RESPONSES TO EDARP COMMENTS – in red

File No. PPR2411, Parcel 5308000074

June 11, 2024

**GREENER PASTEURS, LLC**  
 7280 NEVADA LANE  
 SITE DEVELOPMENT PLAN AND PARKING PLAN

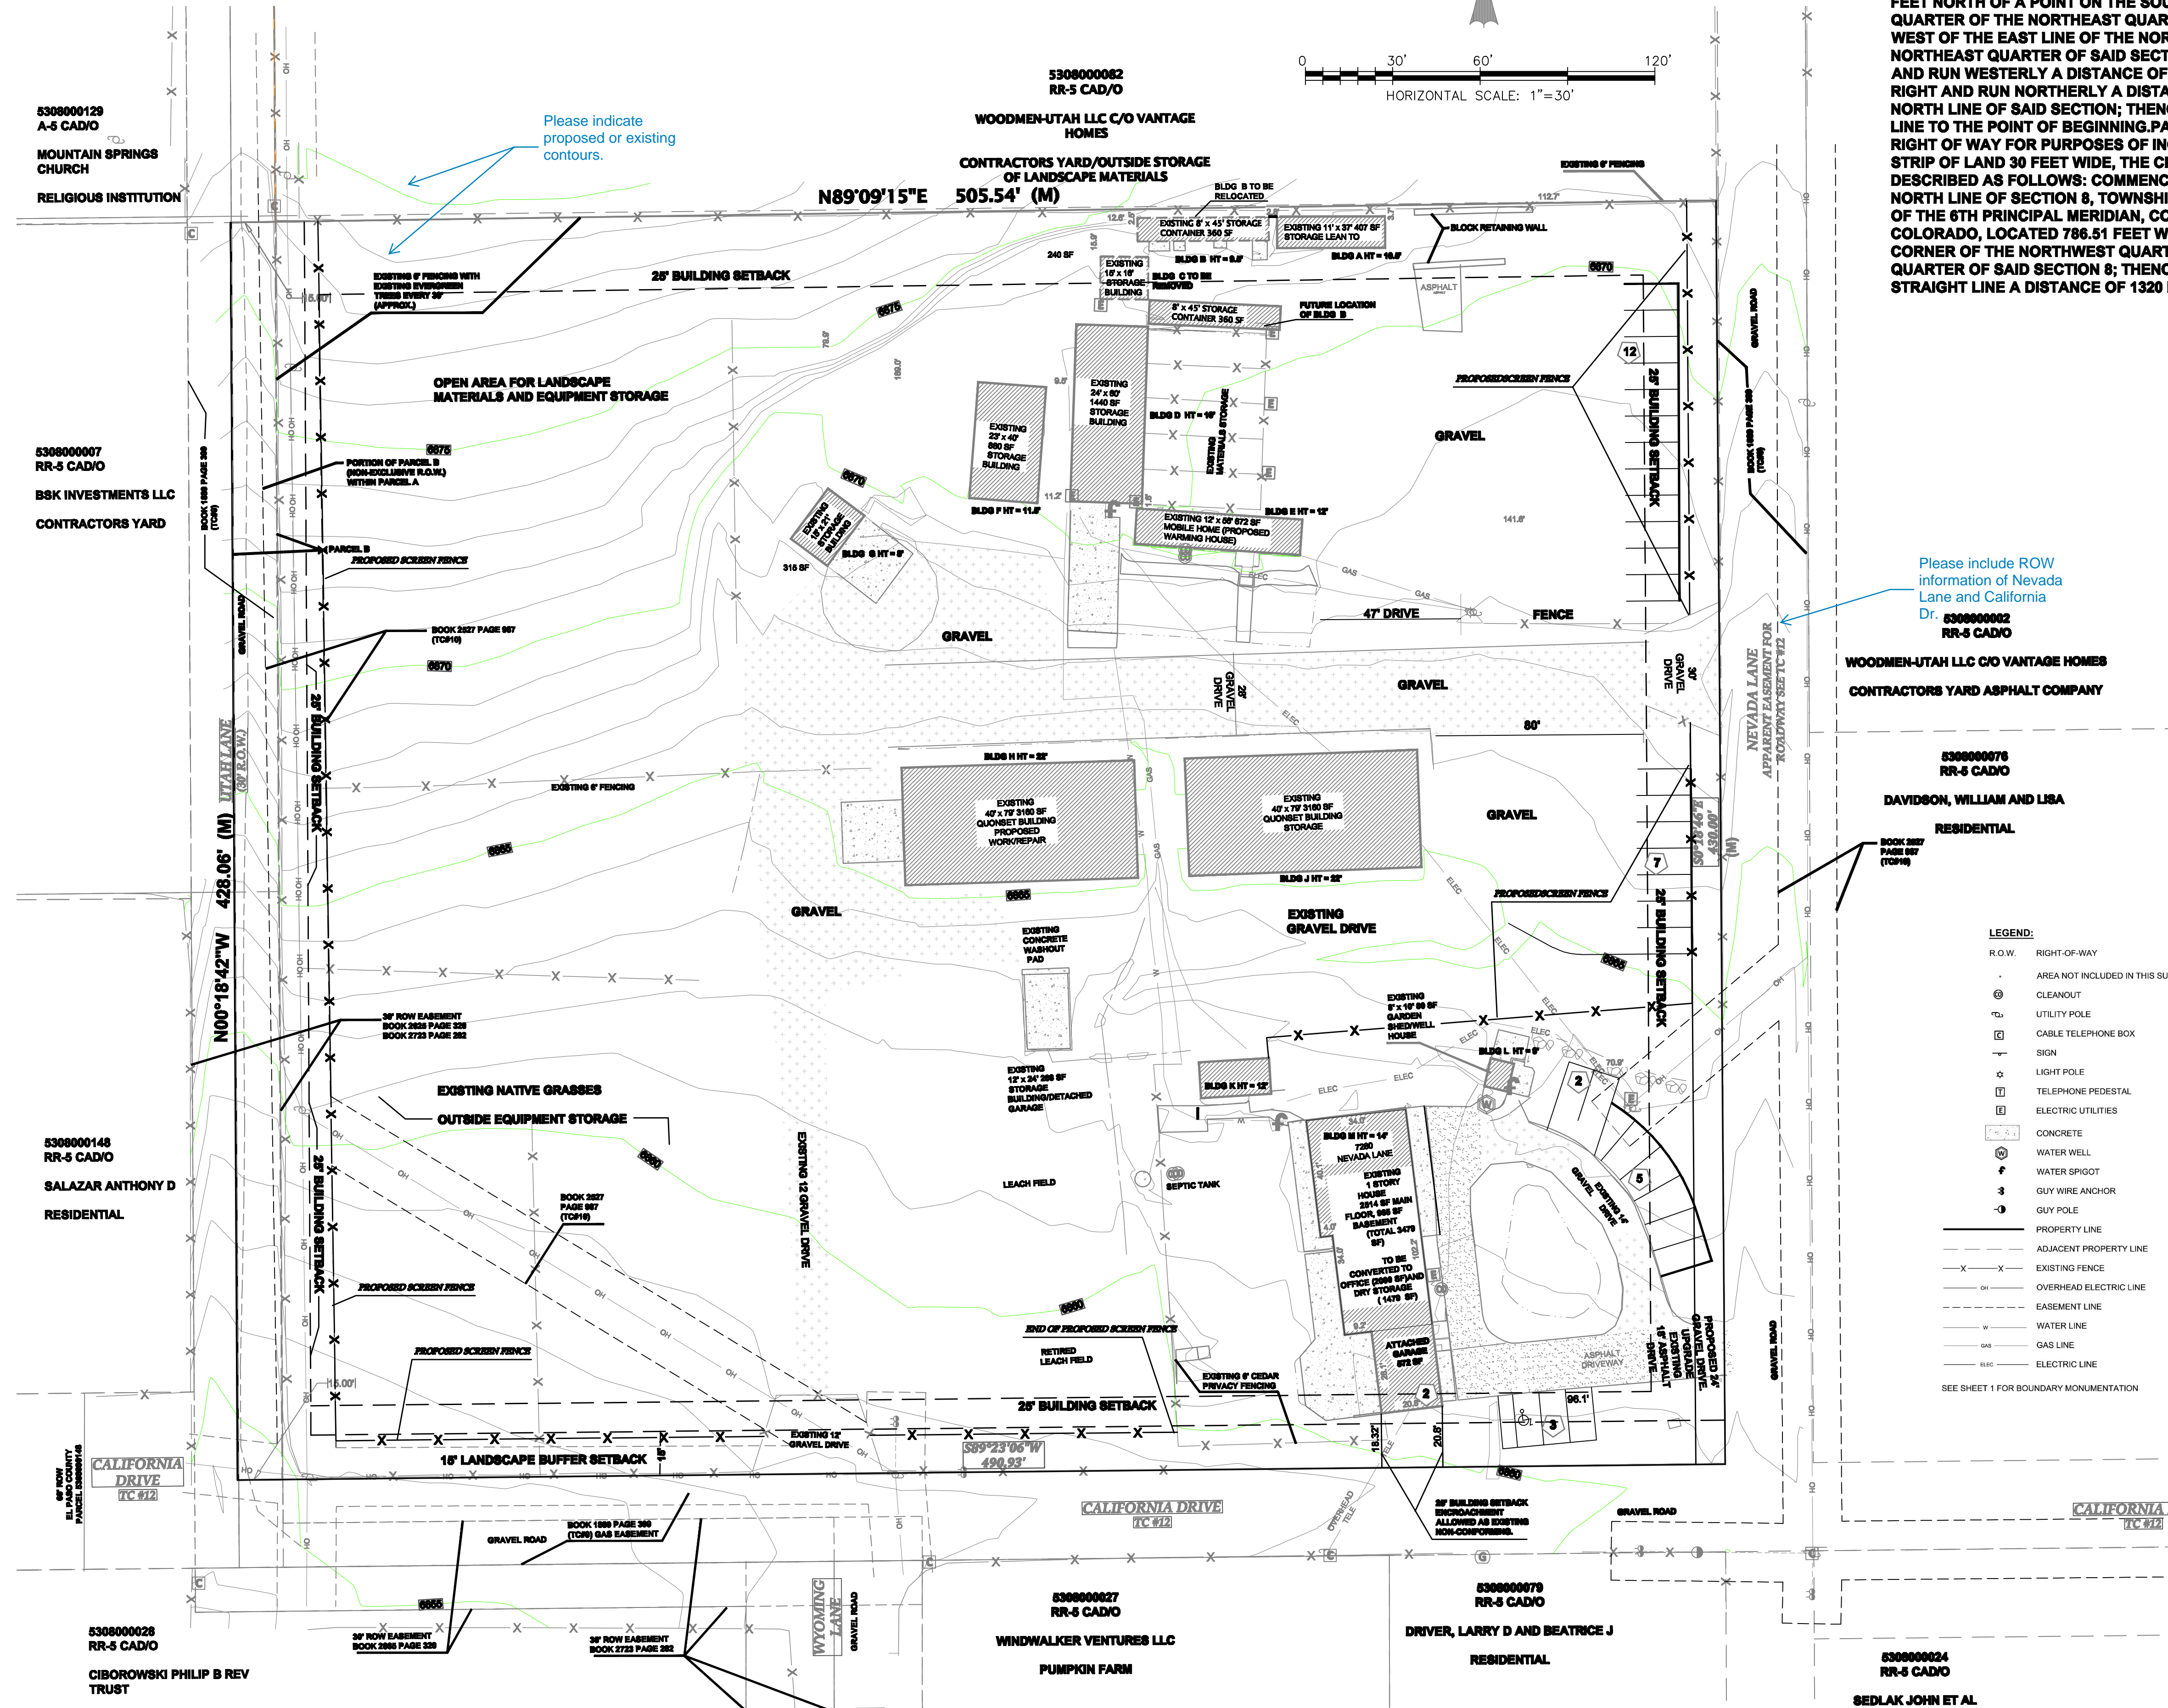
TURNING RADIUS:

A minimum turning radius of 33' inside or 44' outside shall be provided.

*** This is required on site of the property at all times to be able to maneuver fire apparatus.

VERTICAL CLEARANCE:

Fire apparatus access roads shall have an unobstructed vertical clearance of not less than 13-feet 6-inches.

LOADING:

Fire apparatus access roads shall be designed, constructed and maintained to support the imposed loads of fire apparatus weighing at least 75,000-pounds.

GATE LOCK REQUIREMENTS (COMMENTS):

The two gates shall have a Knox Company fire department pad lock installed on each gate for a total of two pad locks. I will provide the model and size when you are ready to purchase the pad locks. Email me at the email address above for further information.

Comments made on Site Development Plan:

- Depending on how comments are addressed on the Drainage Letter, this Plan may need to be modified: example being the potential addition of a PBMP or to show revegetation of unstabilized areas.
- Please include ROW information of Nevada Lane and California Dr.
- Please indicate proposed or existing contours.
- Please include Project No. PPR2411

- Minimum Turning Radii are now noted on the plan and a note was added to emphasize the need to maintain them at all times.
- Jeff Weisburg (Owner) had a recent email exchange with Lieutenant Kauffman (Fire Inspector I). He reviewed our revised Site Development Plan showing the new layout of our fire access road. FFPD response: **"The turnaround and turning radius is acceptable and approved"**

- 12' wide roadway to California gate and culvert are now shown on the revised SDP.

- Minimum vertical clearance in Fire lanes is noted on revised SDP.

- Minimum loading requirements in Fire lanes are noted on revised SDP.

- Knox lock requirements on gates noted on revised SDP.

1. Upper left note:
 - Added a graphic showing the proposed detention pond overlaid on top of the existing topography.
 - Added a note North of the future detention pond to revegetate with mixes noted on the Landscape Plan.

2. Note below that asking to indicate proposed or existing contours:
 - Added contours on SDP.
 - Added in the SDP notes section the following comment: all contours shown on this plan are existing unless otherwise noted in the future detention pond area.

3. Note east of the yard driveway asking for ROW info:
 - Jeff Weisburg (owner) contacted Land Title Insurance Company to ascertain additional ROW information. Our title commitment dated 09-04-2014 states "APPARENT EASEMENTS FOR ROADWAYS ALONG THE EASTERLY (NEVADA LANE), SOUTHERLY (CALIFORNIA DRIVE), AND WESTERLY (UTAH LANE) PORTIONS OF SUBJECT PROPERTY".

- The Right of Way for California Drive appears to be vested in the 30' easement noted at the southeast corner of the property. 30' row easement, Book 2865, Page 320. Also see Book 2723 Page 282, which is noted to the east.

4. Note in lower right corner asking for project #:
 - Added project # to all sheets.

BUILDING B ELEVATIONS  
SUPPLY STORAGE CONTAINER TO BE RELOCATED

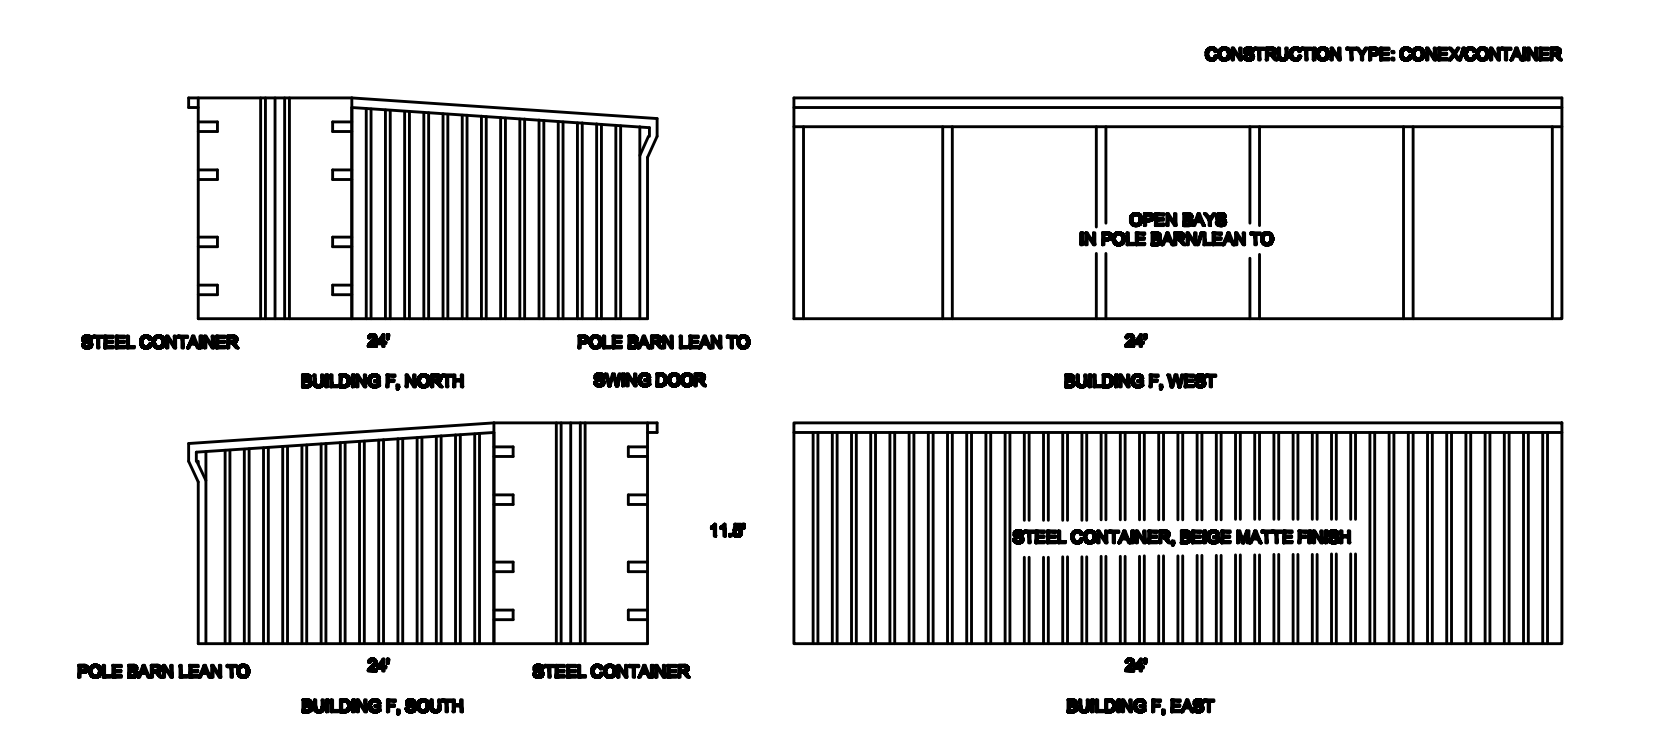
8x45 storage container, that is to be relocated on the property. What does future building B look like? Provide the size and use?
